Application No 2018/92216

Date 2/8/18

Further to the application for residential Development on land off Netherley Drive Marsden we the residents adjacent to the site vermantly object to the proposed Development and our objections are as follows :-

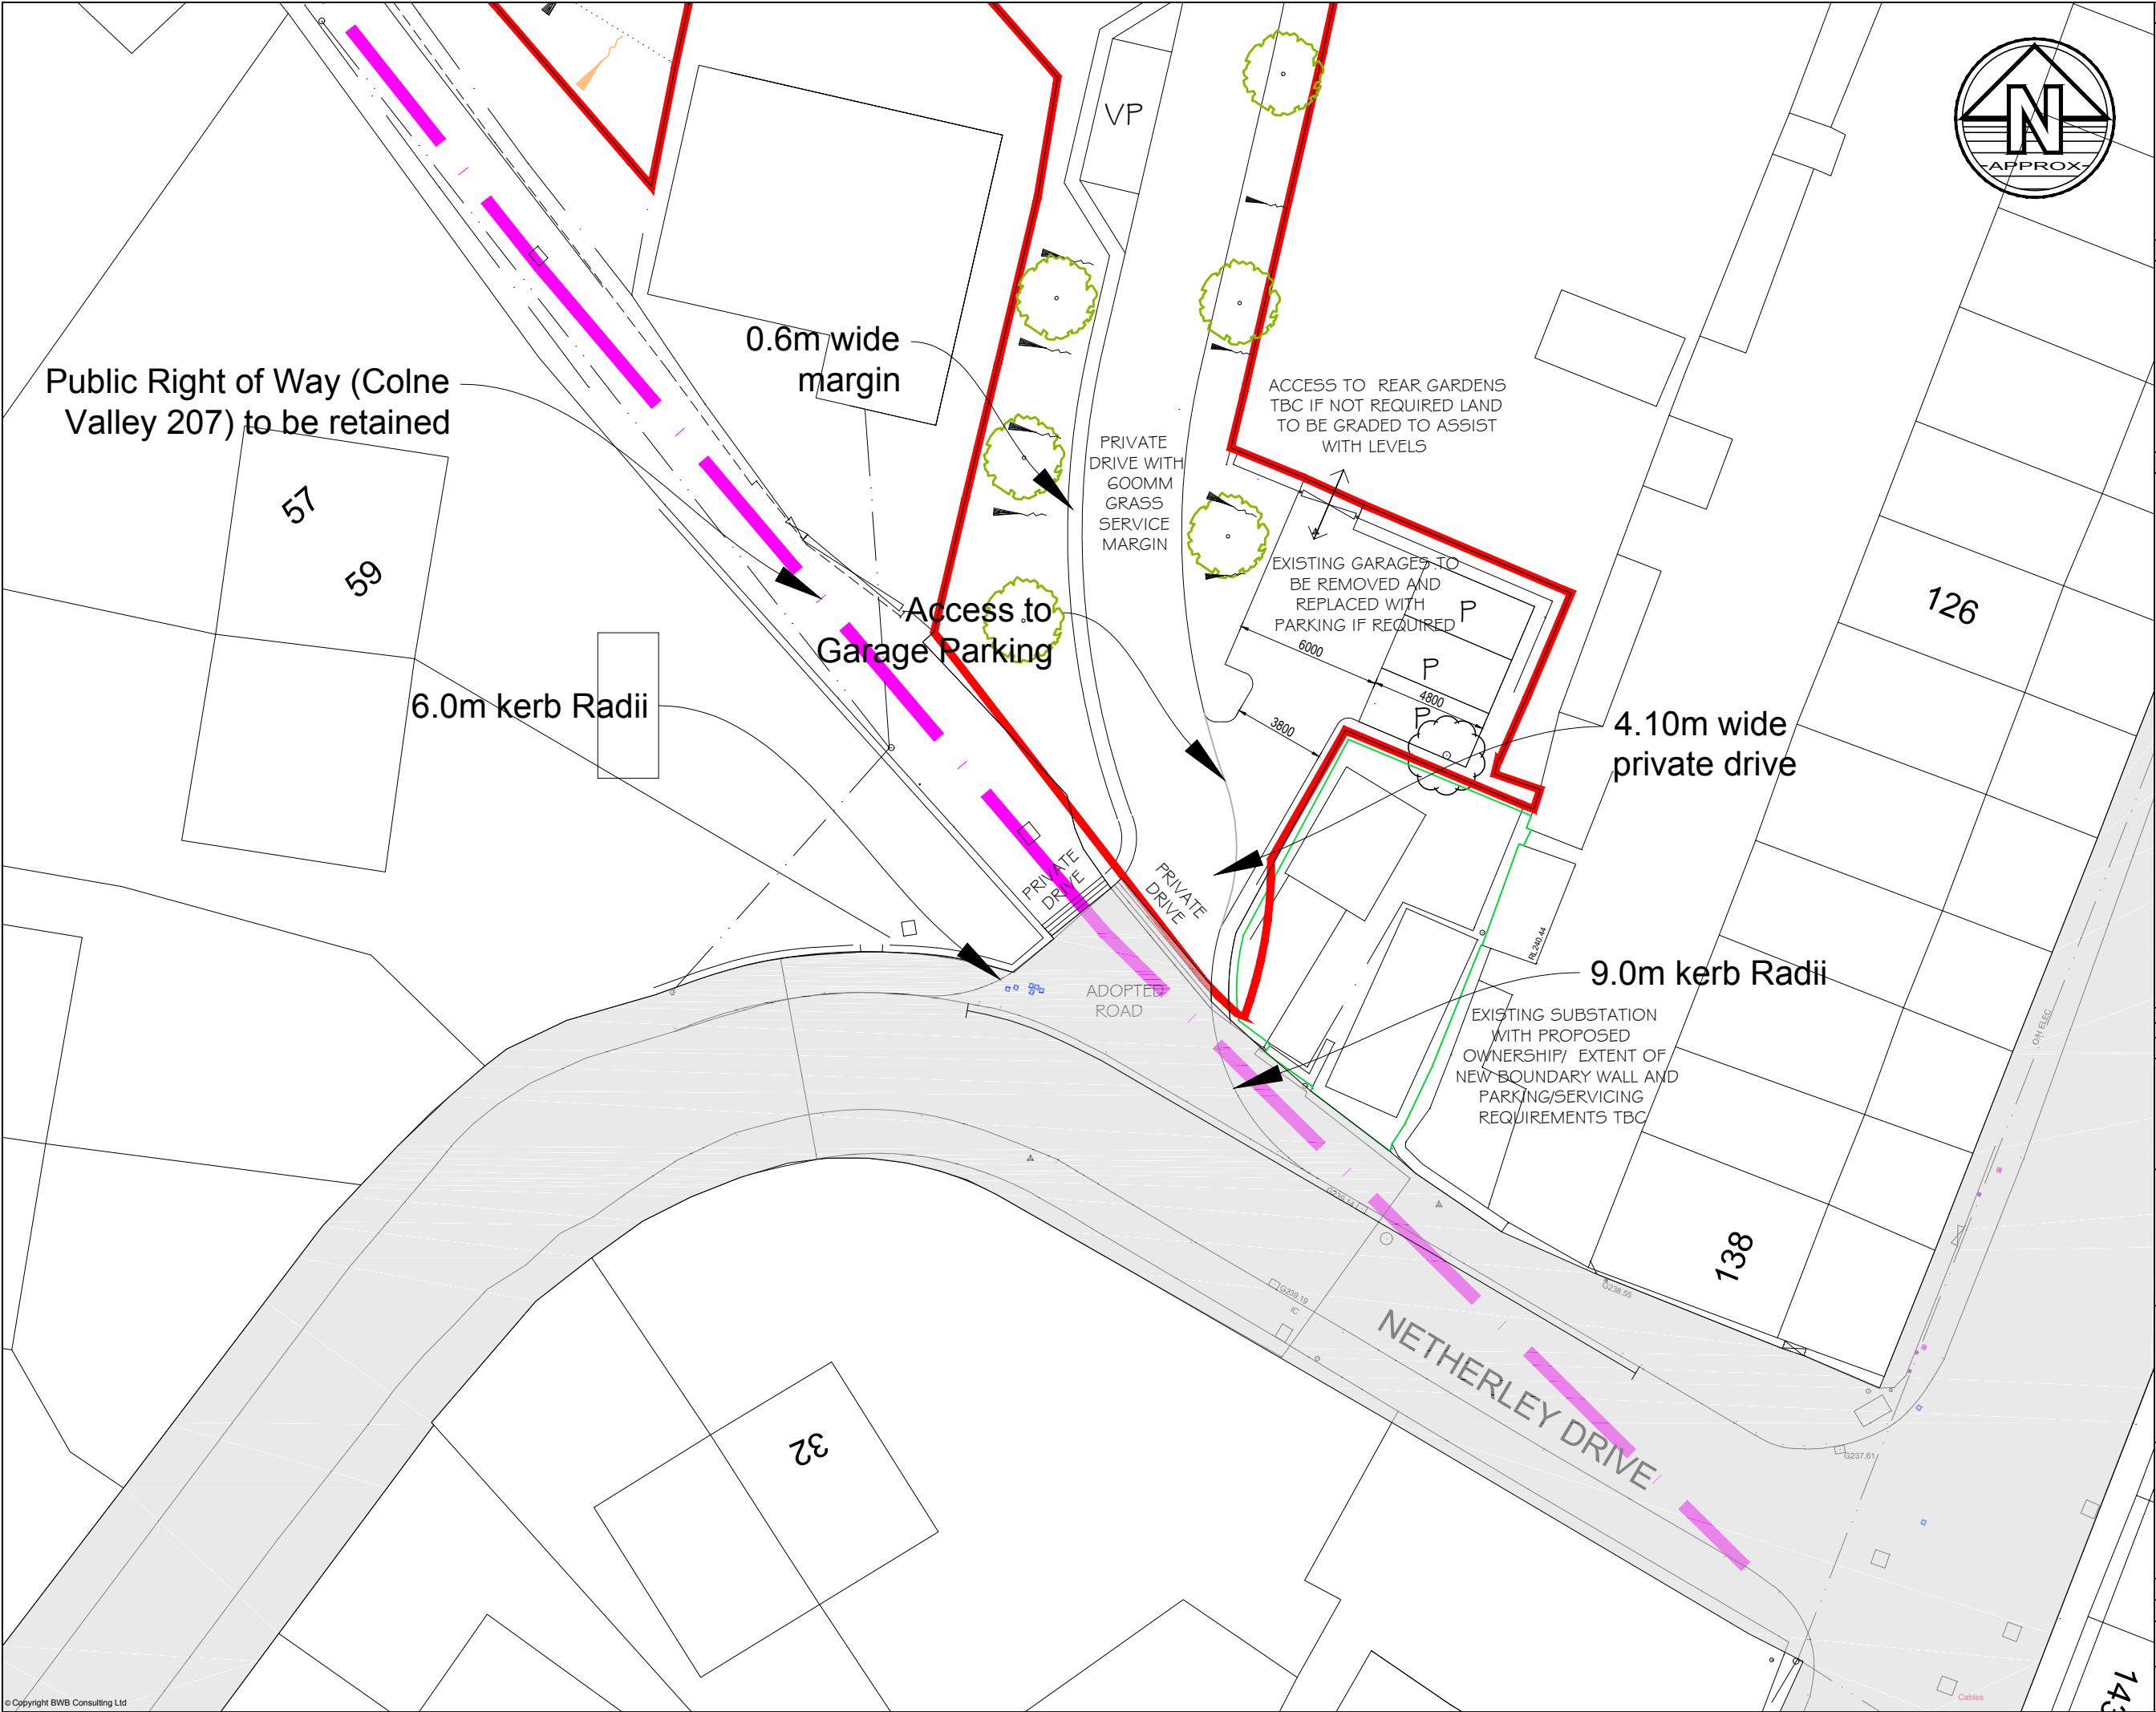
- A) The site proposed entry off Netherley drive is inadequate for purpose and is a bottleneck as is and to introduce another possible 5 Properties would introduce a possible 25 vehicles using a single track entry via a bridleway / public footpath, The road Netherley Drive is only 4 metres wide and cars park all the time on this road only leaving a narrow gab just wide enough to get one car through at a time this is an accident waiting to happen!

- G) The developer has submitted a road usage plan for netherley drive, this plan is flawed as the road is only a single track road at all times and could be classed as a one way system, Also Mount road is also at best a single track road due to cars parked on both sides of the road, this is why the road traffic accident total is nil, because only one car can pass at any one time.

Proposed Site Layout

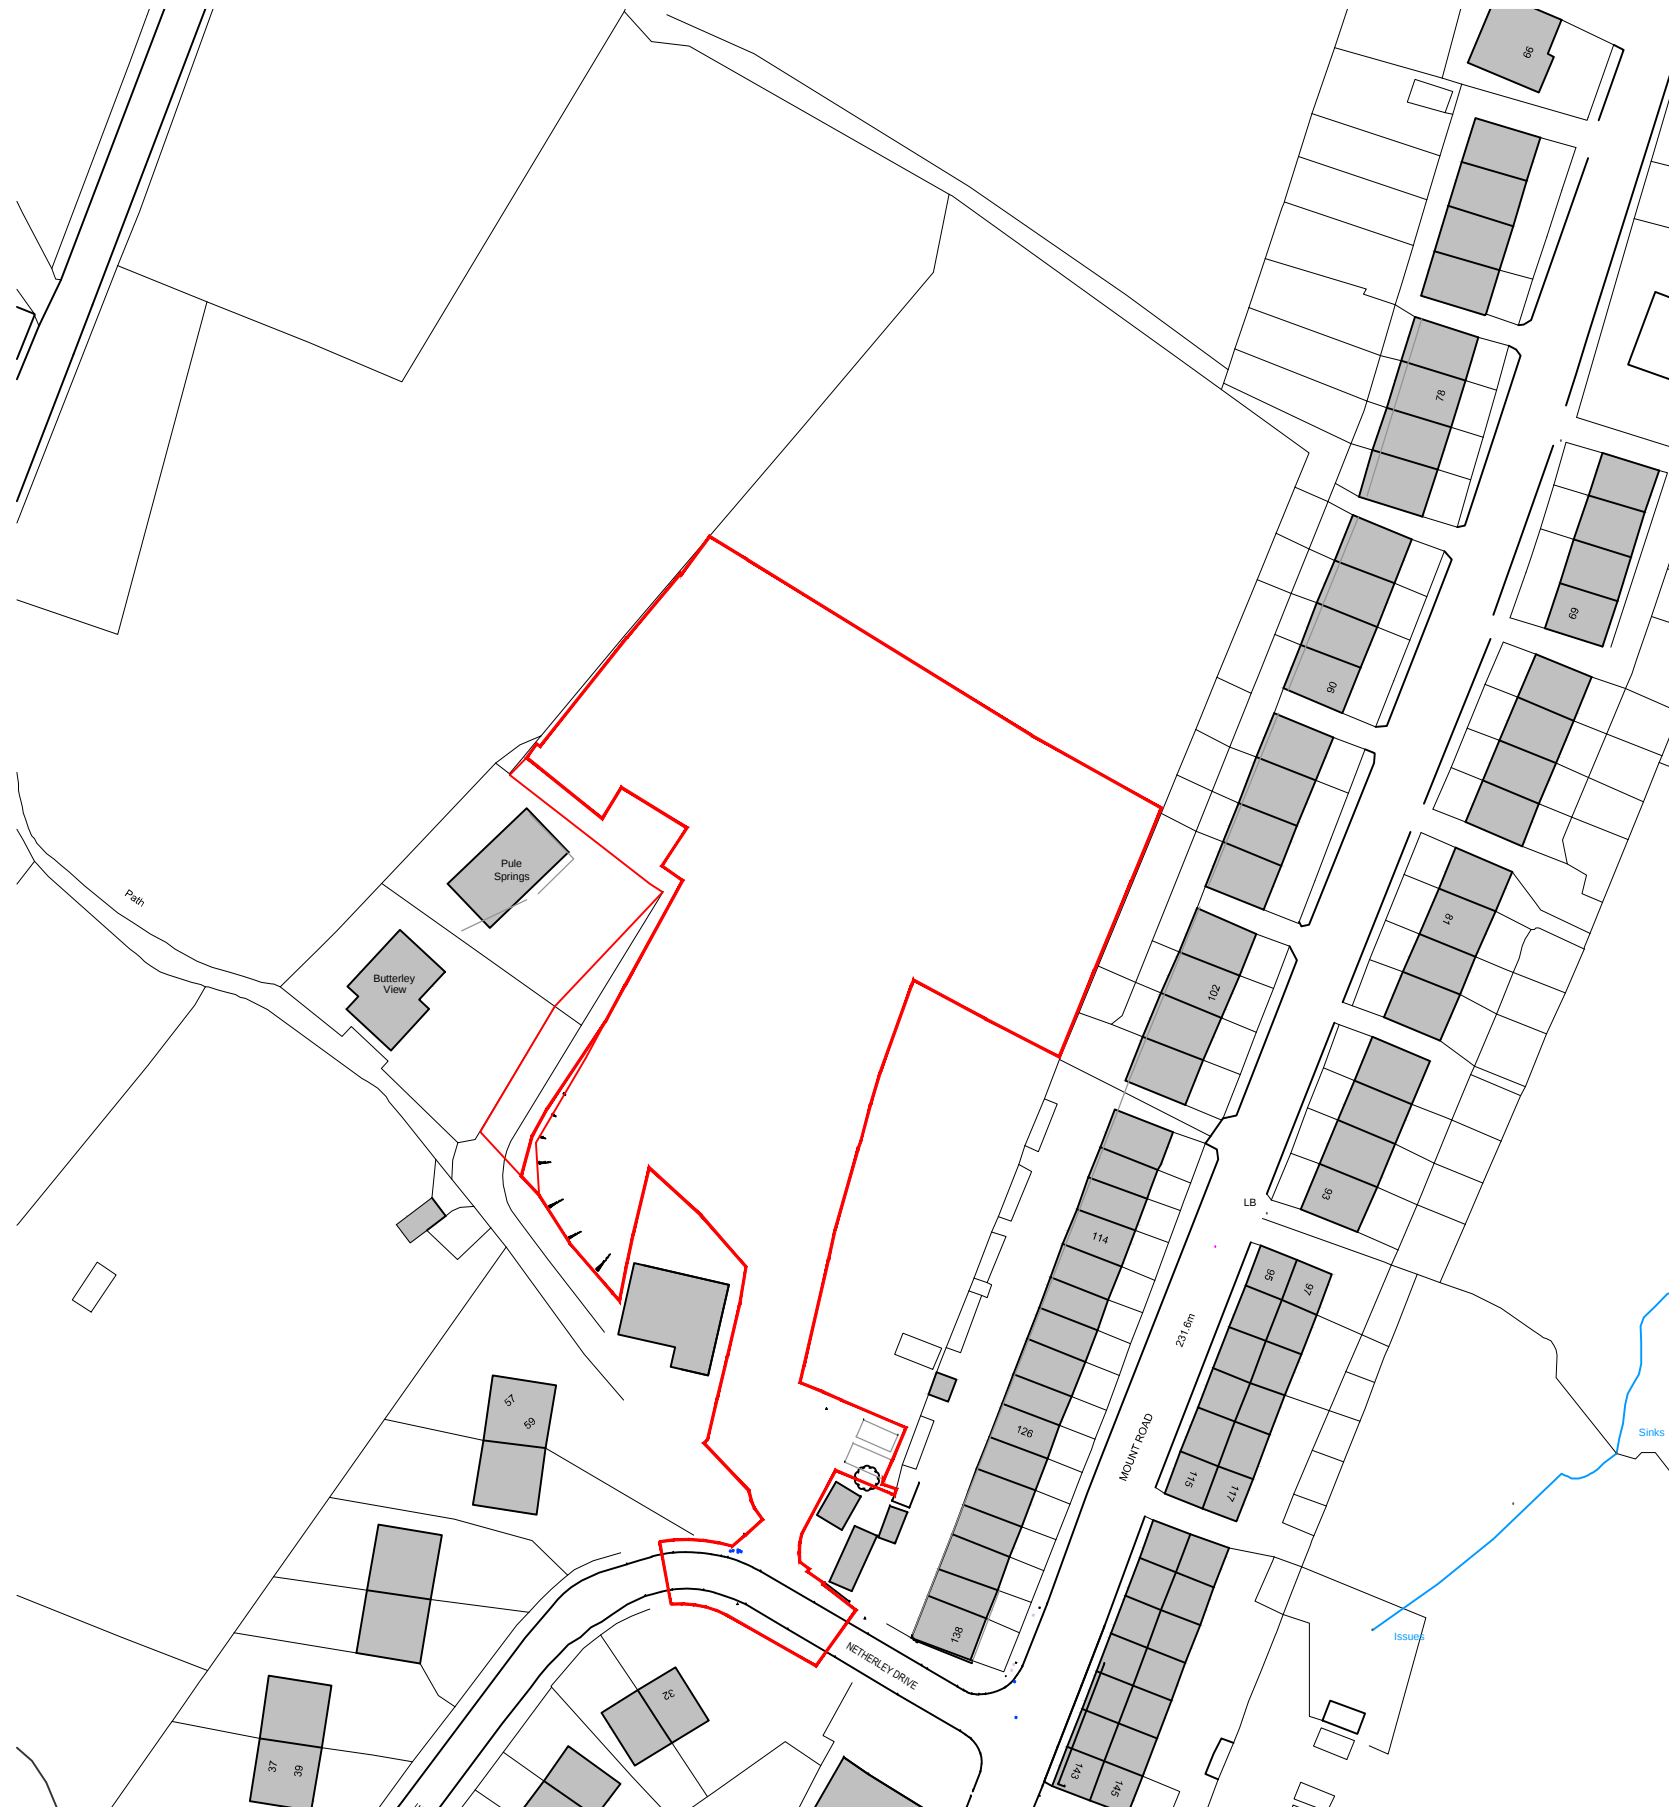
- B) The Proposed site has been classified as land not to be developed by yourselves we believe it is classified as group B Land!!
- C) The plans from the developer shows part of My property been built on the proposed entrance into my property , we have not given any indication to the developer this is acceptable again contravenes building plans

- F) The proposed development is for 5 x 5 bedroom houses that encroach on our property ie within 25 metres this I believe contravenes planning conditions
